From: Graham Moore [REDACTED]
Sent: 29 March 2018 12:17
To: Ross Leal
Subject: RE: Planning Consultation on: AB/16/18/L

APPLICATION AB/16/18/L

Site Address: Longmace House 8A The High Street Arundel BN17 9AH

Description of Works: Listed building consent for the part change of use from business (A2 Financial & Professional Services) to residential use (C3 Dwellinghouse) on part ground, 1st & 2nd floors.

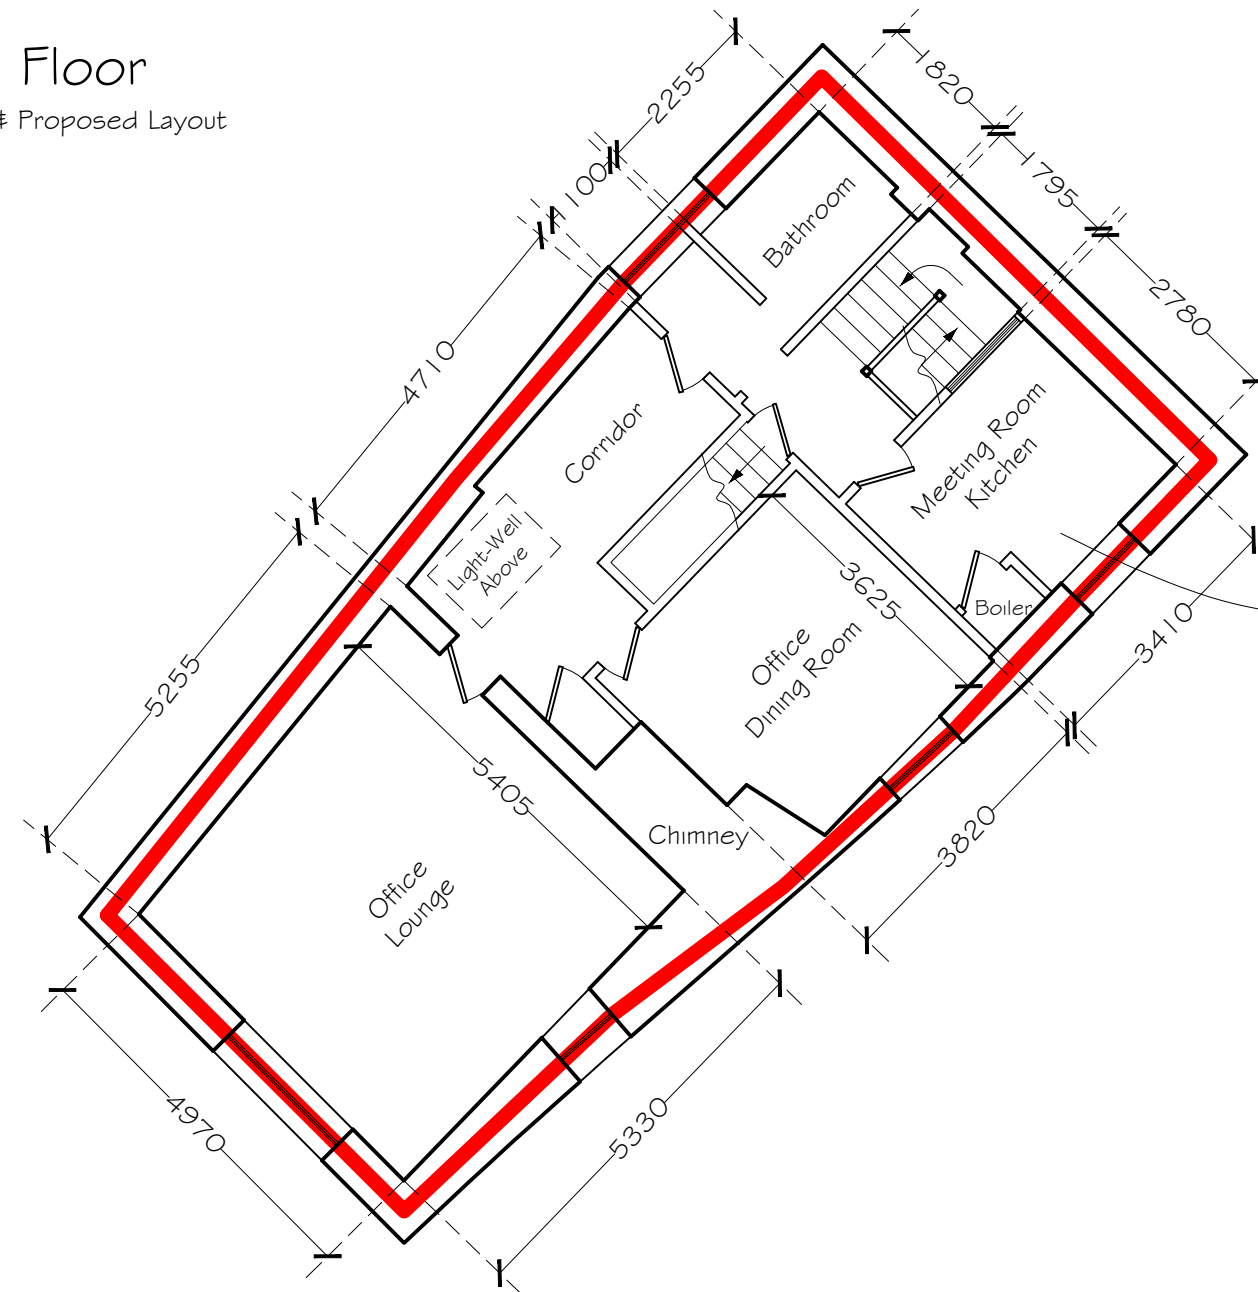
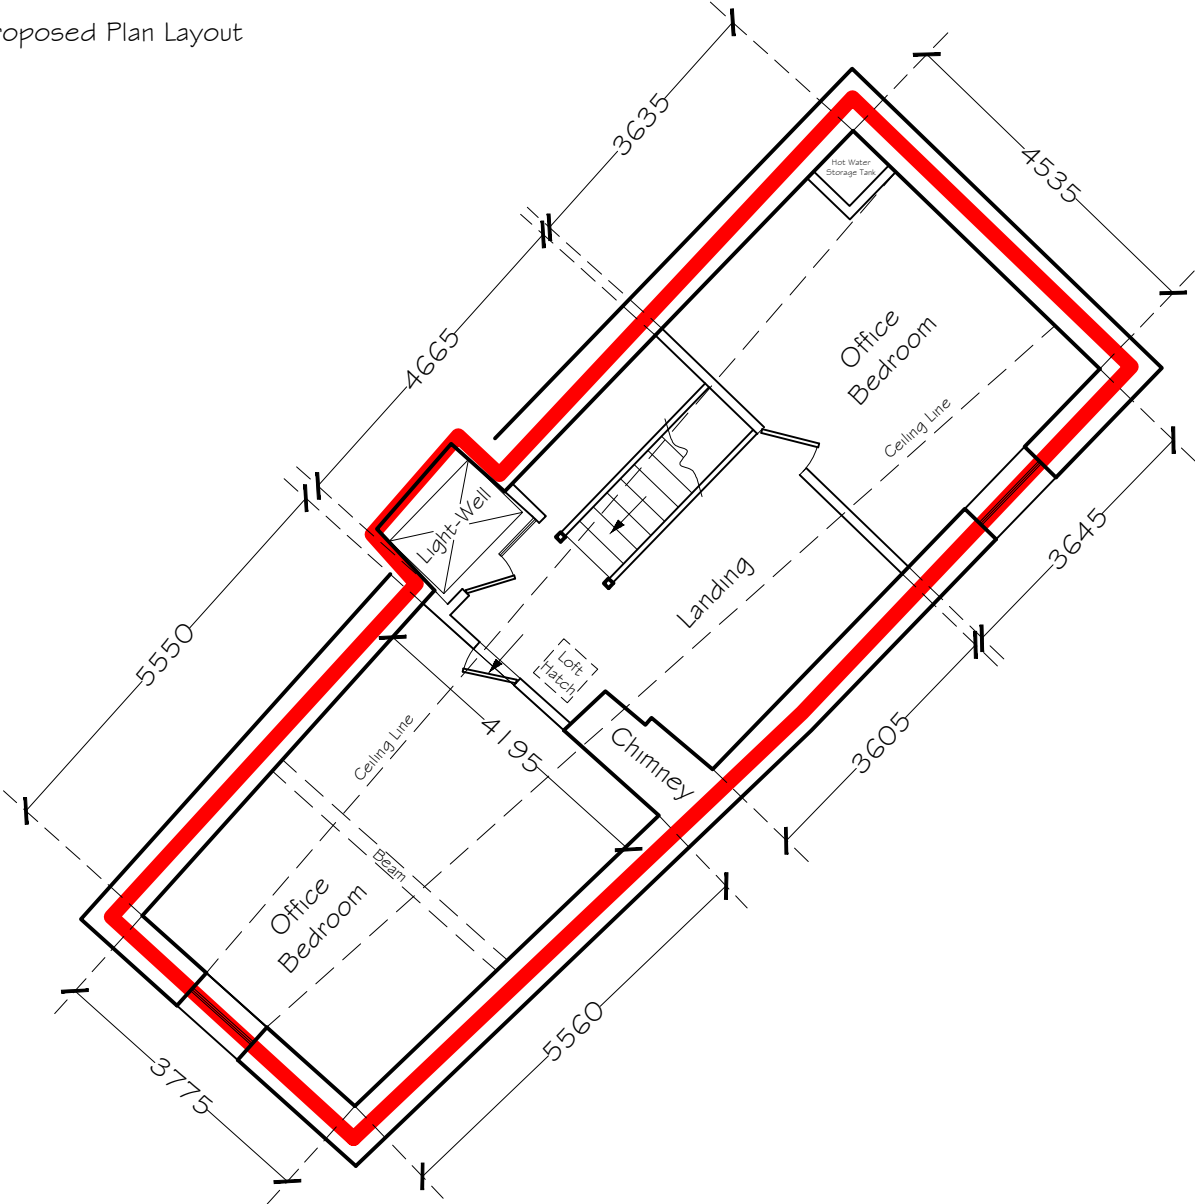
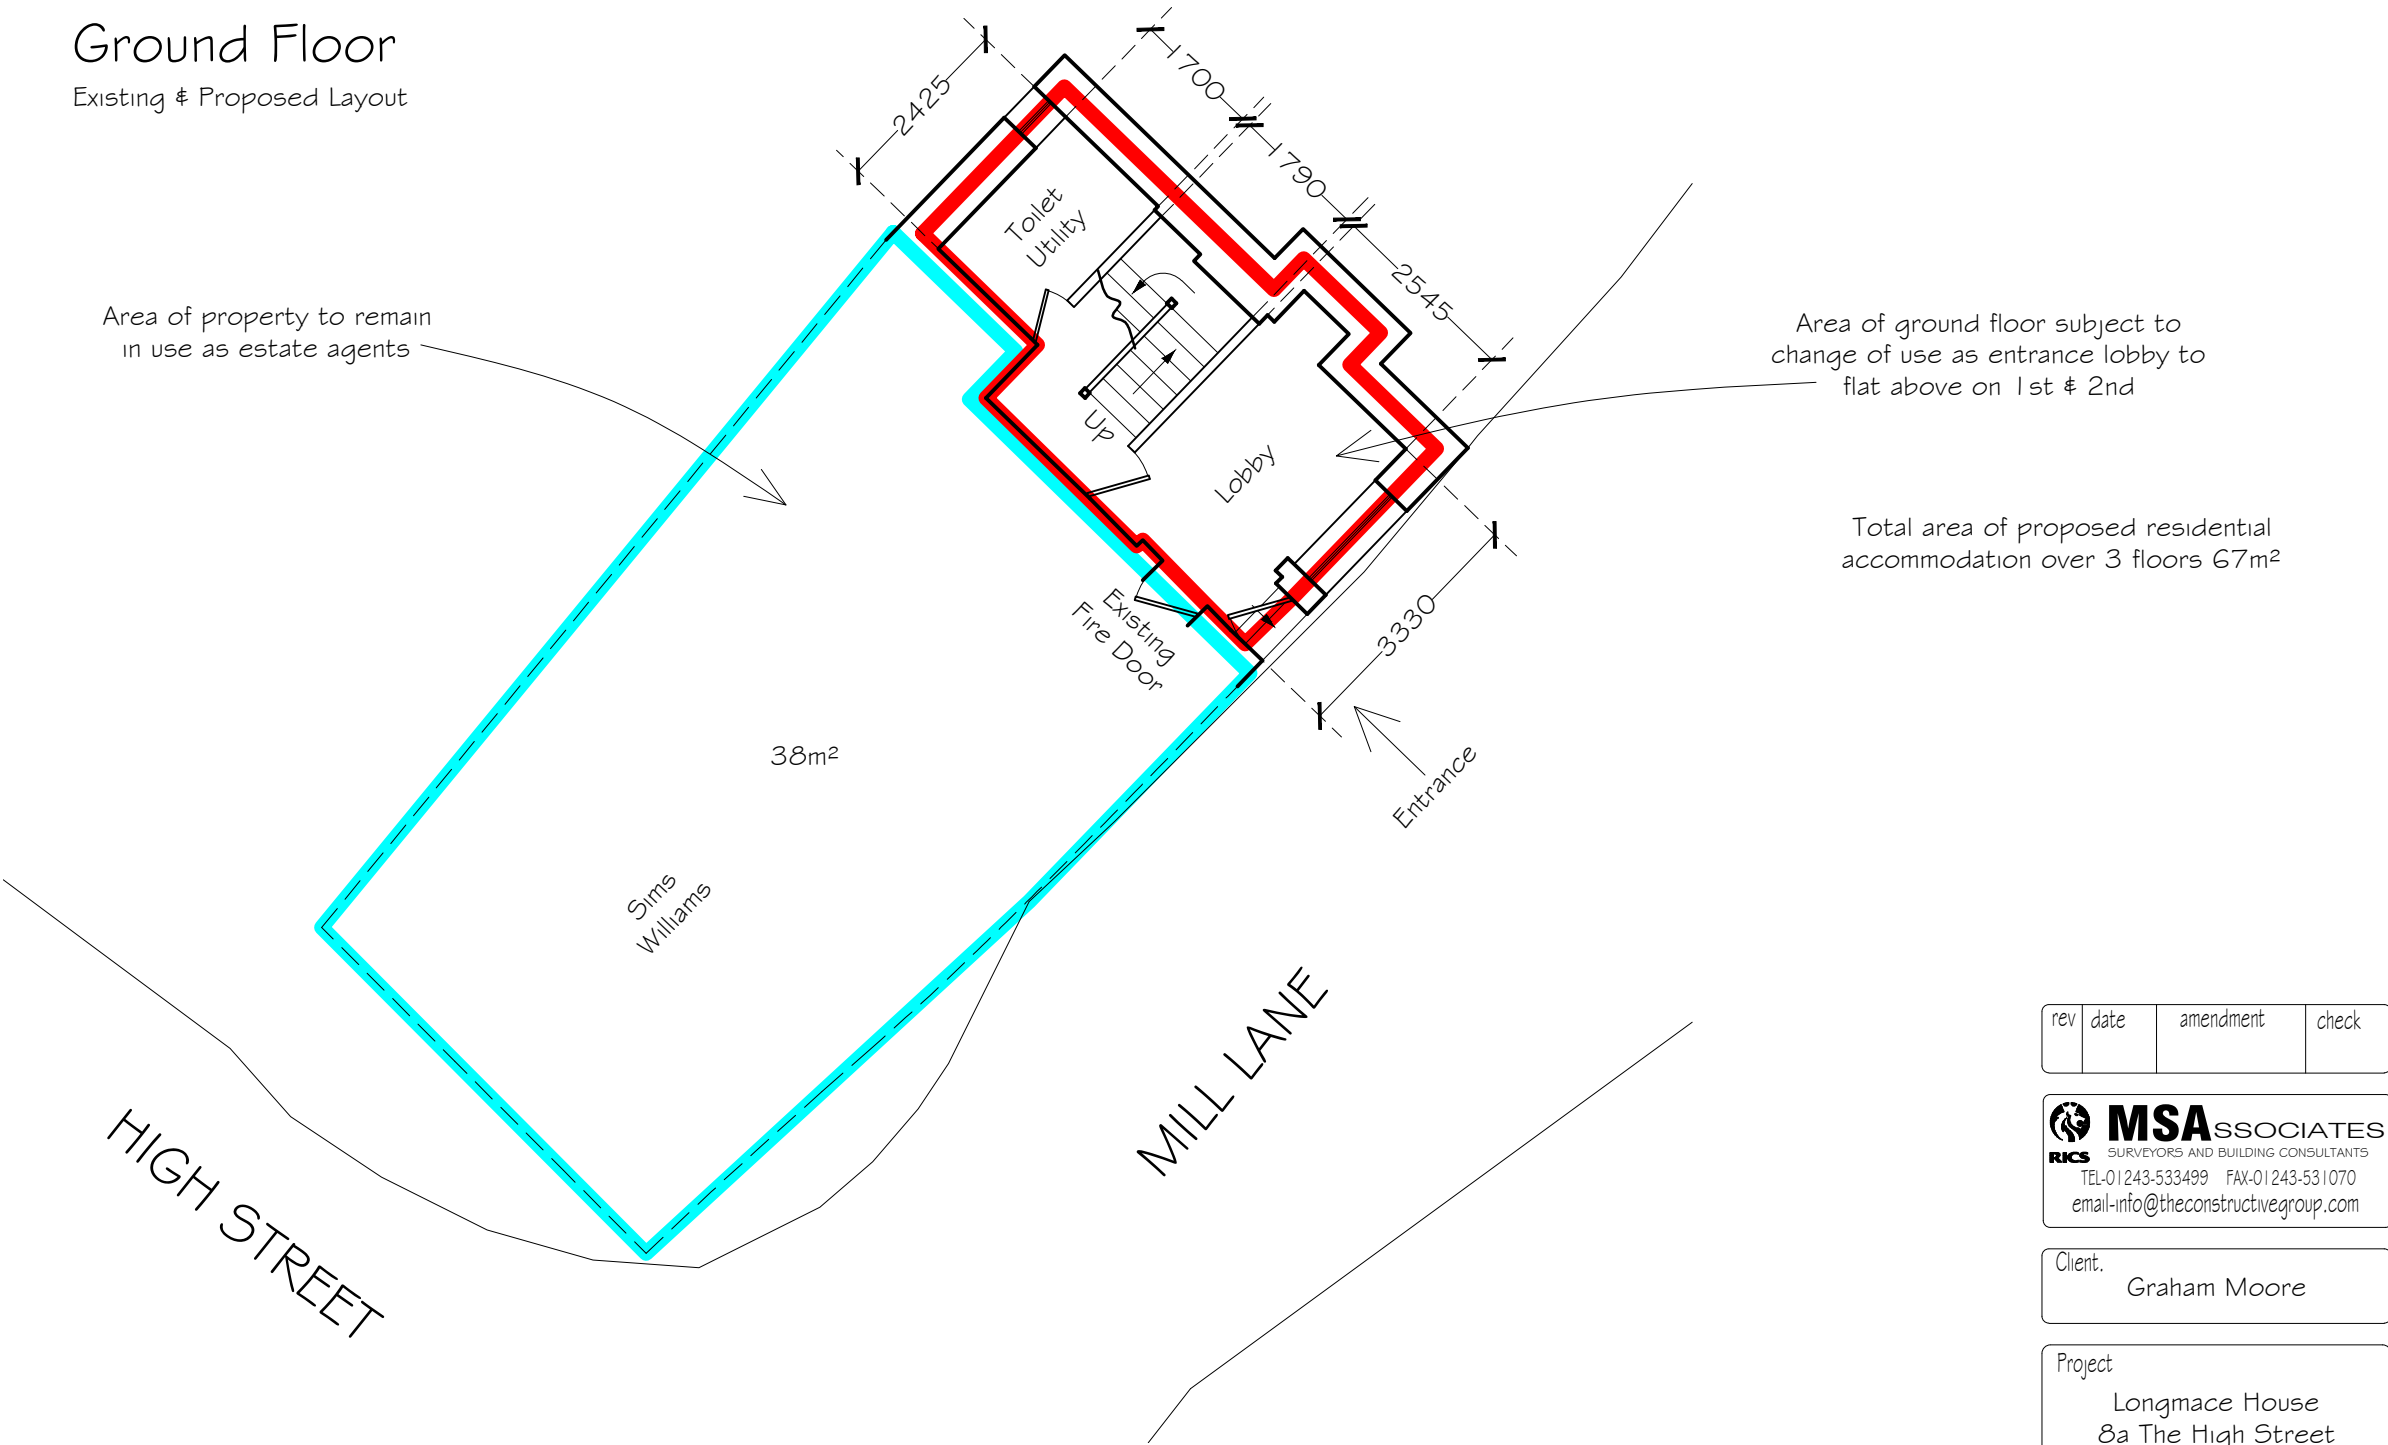
We require you to clarify how the change of use will be achieved and detail any internal alterations required. If there are no alterations, then this needs to be explained. We need to be clear as to exactly what the change of use will involve and the method which would be used to achieve this.

I have been invited to make comment on the below application. While there are no general concerns on the Change of Use from a Conservation point of view, there are no details given on how this the applicant wishes to achieve this. The submitted drawings are marked 'Existing & Proposed', with general comments eg 'bathroom', without any methodology. It is therefore my professional opinion that there are insufficient details to properly comment on this application. I would be pleased to meet the applicant to discuss.

The layout remains as it was when it was residential so there are no internal alterations proposed.

In fact, the bathroom retains a bath and has not been altered at all.

I suspect that we should replace the sanitaryware and kitchen units but all services remain for direct replacement.
